**DELEGATED DECISION TO DETERMINE PLANNING APPLICATIONS**

Reference No:	<b>2024/62/92173/W</b>
Site Address:	43, Netherton Moor Road, Netherton, Huddersfield, HD4 7JF
Description:	Erection of boundary fence
Recommending Officer:	Joanna Rednall

**DECISION – CONDITIONAL FULL PERMISSION**

**Fence Elevations**  
scale 1:50

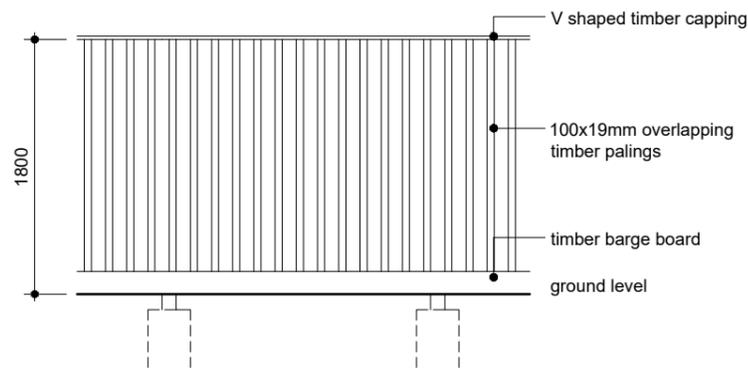
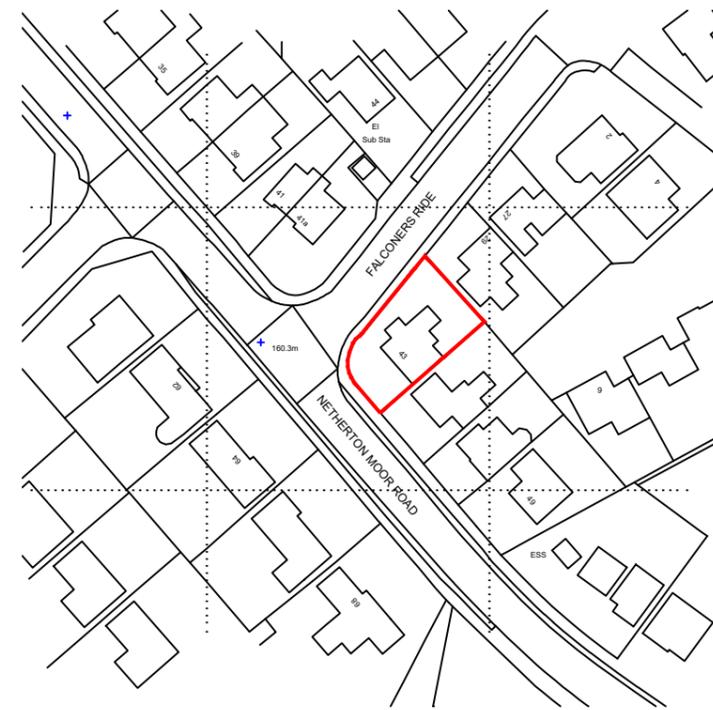
The proposal is for 1.8m timber fencing around the north-east and north-west facing boundaries of 43, Netherton Moor Road. The submitted plans indicate that the existing hedge was removed to facilitate the fence. Upon a site visit, it was noted the predominant boundary treatments would remain hedging within the immediate surrounding area of the site. As the property is located within a prominent location and occupies a corner plot, the colour finish does not appear to appropriately harmonise with the vernacular of the street scene and residential development which the site is situated. It is therefore recommended that a condition to be added for the fencing to be of dark colour finish.

2. The fence hereby approved shall be painted or powder coated in a dark green colour finish within 3 months of the grant of planning permission. This colour finish shall thereafter be retained.
